# CITY OF ALBUQUERQUE

RE: **Andalucia Phase 1, Bldgs A, B, and C**  
**5600 Coors Blvd NW**  
**Request for Certificate of Occupancy – Permanent**  
**Hydrology Final Inspection - Approved**  
**Engineer's Stamp Date 2/3/17 (E12D015D)**  
**Certification Dated: 4/25/18**

Re: Andalucia Phase 1 Bldgs A, B and C (Hydro # E12D015D) comment letter

PROPOSED DRAINAGE MANAGEMENT PLAN

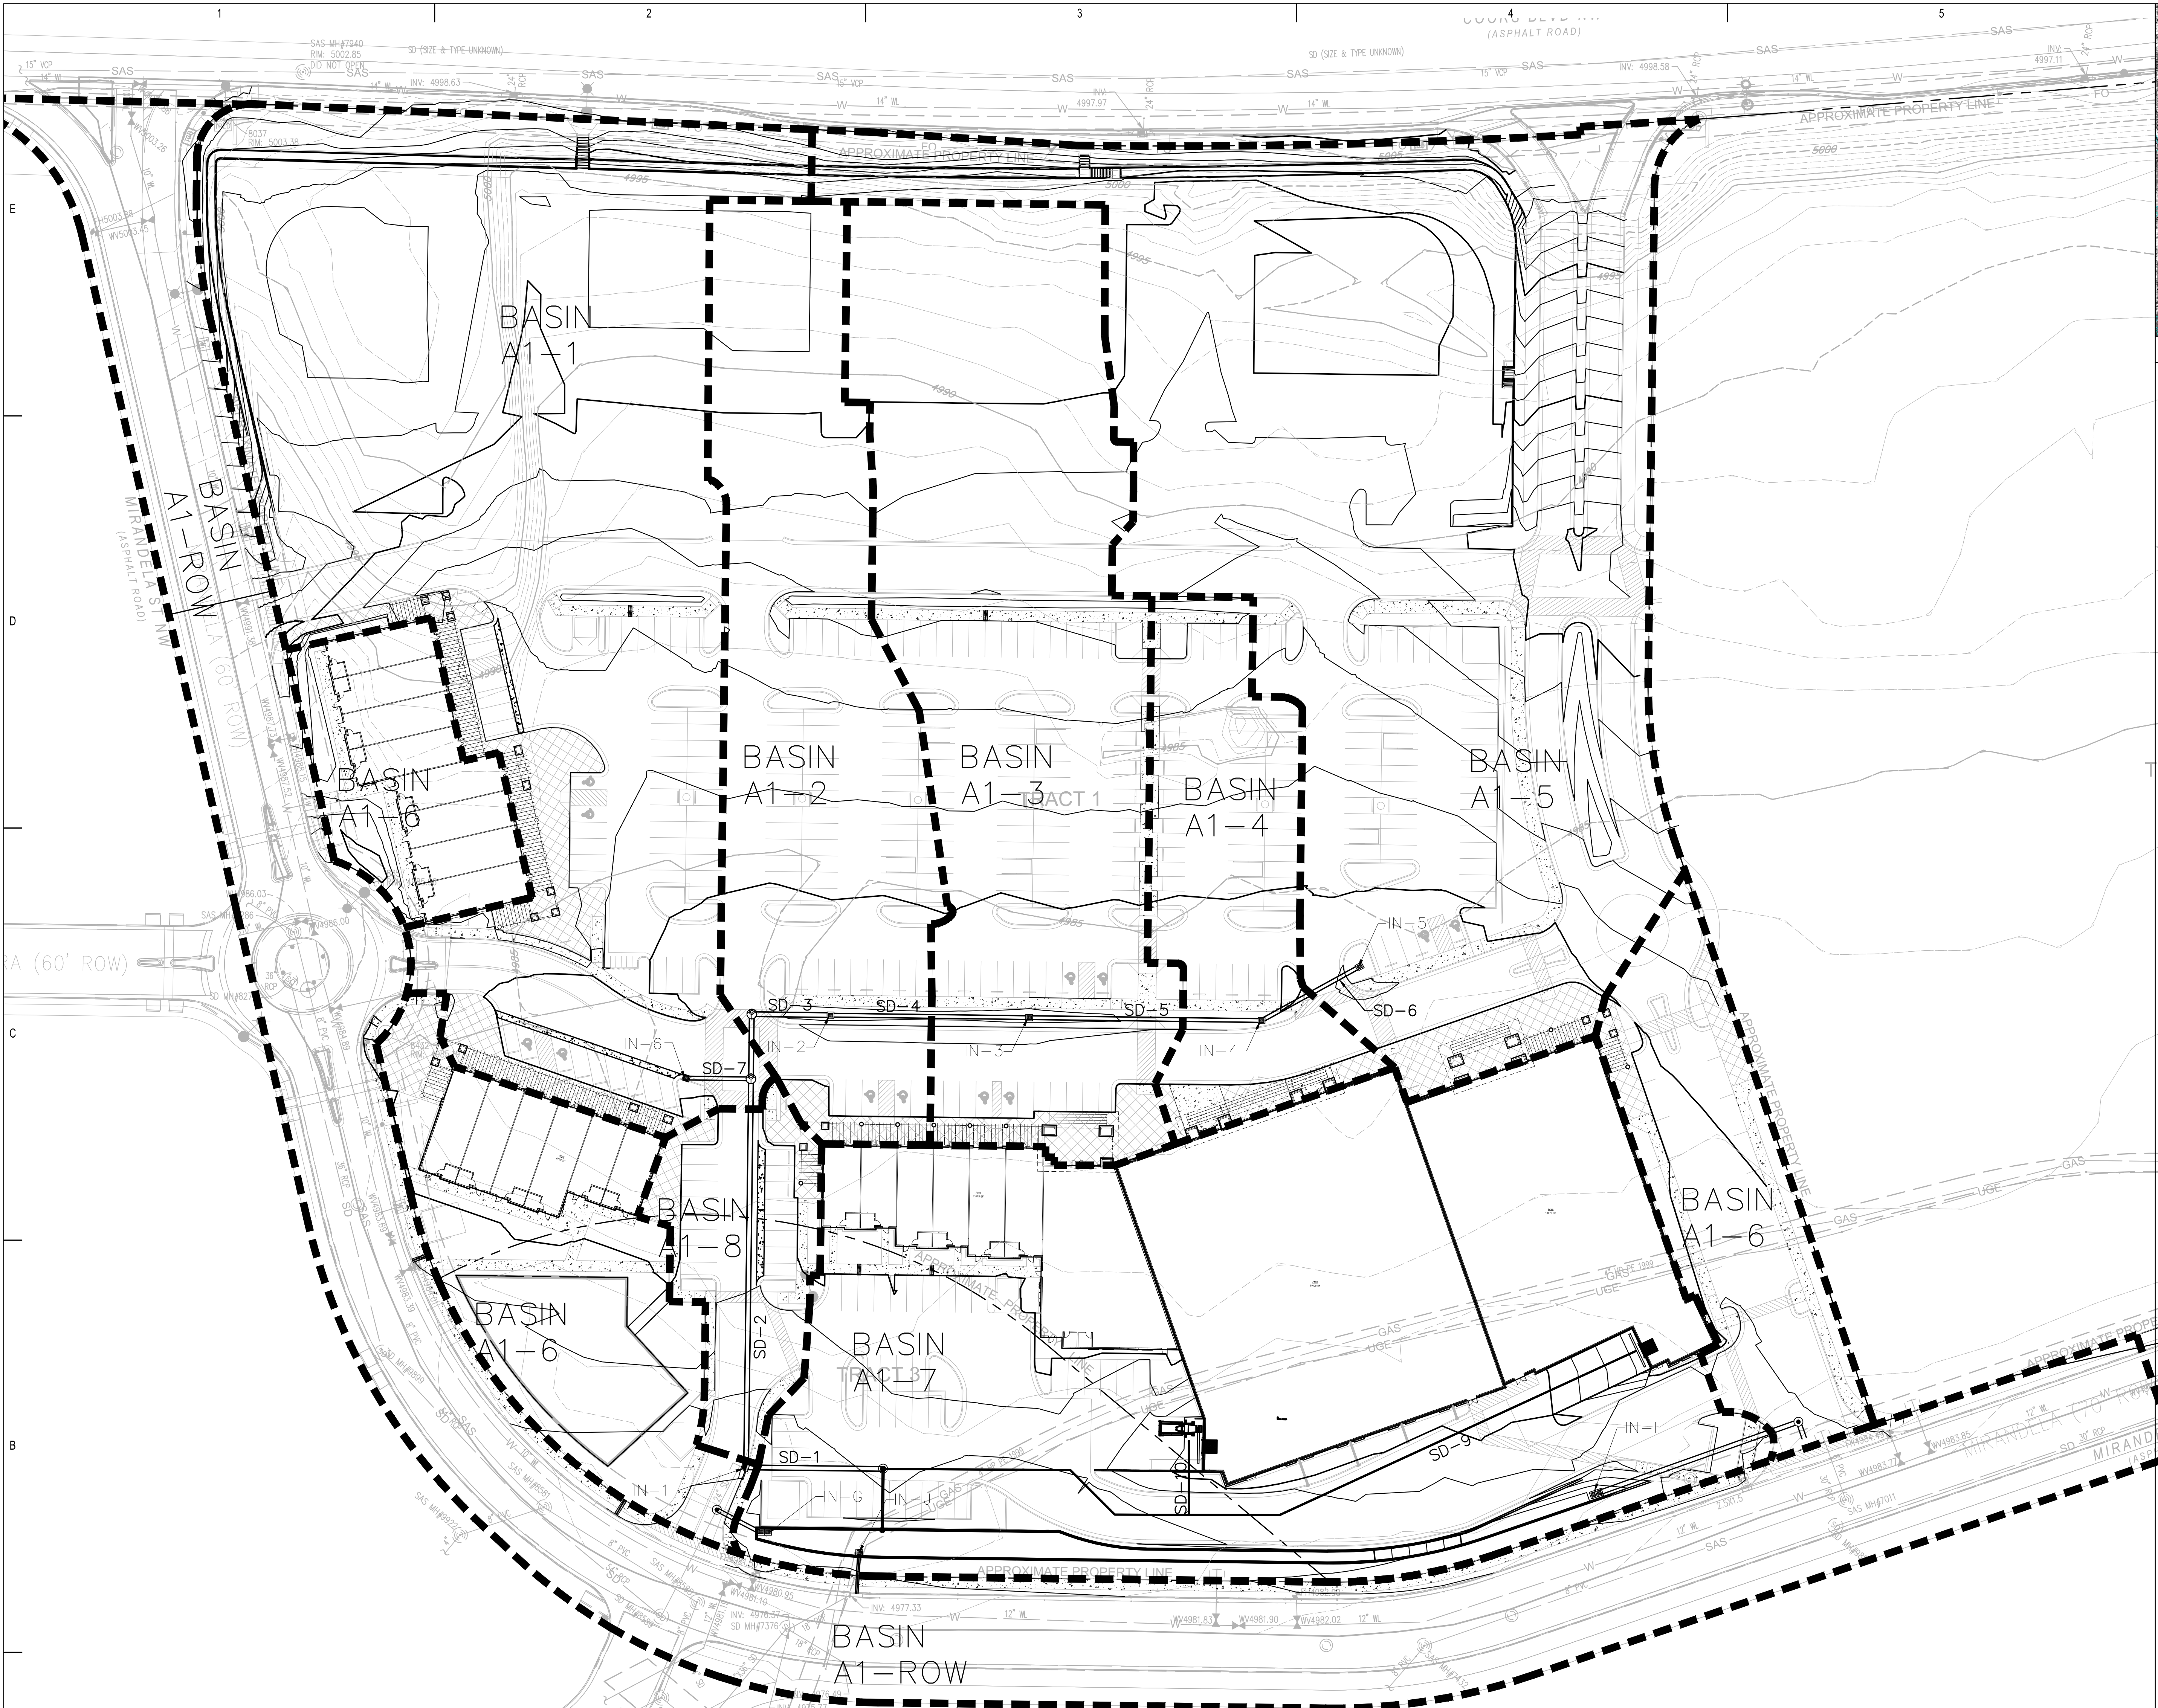
1. Include detailed descriptions of what Revisions 1 and Revisions 2 are. This may be included on the Grading Plan or as a separate letter.

2. The Drainage Plan and its calculation will need to be updated to reflect these revisions and included with the submittal with the new stamp date.  
*Response: The drainage and hydrology calculations noted within the original approved drainage management plan have not deviated from the original intent. The revisions were intended to provide clarity in the field resulting in a better product which more effectively meets the intent of the approved plan. Given the above list of revisions we do not plan to issue a revised drainage management plan.*

3. The sidewalk culverts behind building B along Mirandela, were not constructed and should be as-built as such. Include justification for not constructing these culverts as a separate paragraph in the drainage certification.  
*Response: The sidewalk culverts were noted on the recent drainage certification submitted 4/20 as to be constructed in the future upon development of the outstanding building pad. These culverts can be deferred to the future as the current drainage enters depressed ponding areas that will not adversely affect the buildings during large storm events.*

4. The stairwells through the retaining walls along Coors and the north driveway are incomplete or were not constructed and should be as-built as such. Include justification for no constructed these stairwells as a separate paragraph in the drainage certification.  
*Response: The stairwells along Coors currently access the Phase 2 project and cannot be used until Phase 2 is complete. The developer has opted to not construct them at this time to help prevent access to the construction area. The stairs will be addressed prior to acceptance of the Phase 2 work.*

5. The loading dock behind PetSmart is incomplete and should be as-built as such. Permanent CO cannot be approved with the loading dock being complete. However, a Temporary CO can be granted to allow for this section to be completed later. Also include justification for not constructing this loading dock in the drainage certification.

6. The erosion control wattles along the upstream building pads near Coors (key note 12) were not installed. These need to be installed prior to CO. Alternatively, curb cutbacks and track-out can be used and wattles added only at the closed drive entrances: this will need to be as-built as such, with justification added to the drainage certification.

*Response: The revisions completed were specific to cosmetic changes that are generally addressed in a sketch or other type of drawing issued in the field. New sheets were submitted for ease of tracking. The calculations and hydrology did not deviate from what was originally approved.*

*Response: The loading dock has been constructed and this comment has been addressed.*

*Response: It is noted on the drainage certification dated 4/20 that the wattles have been installed at two entrances and track-out has been provided in one of the other entrances for access. New curb and sidewalk along the majority of the west edge, along with the first road of parking stalls has been constructed. The existing grades internal to Phase 2 sit below the top of curb or sidewalk along this edge allowing water to pond behind them until it fills up and flows over the top of sidewalk. During large storm events, this prevents sediment from entering the existing asphalt drive.*
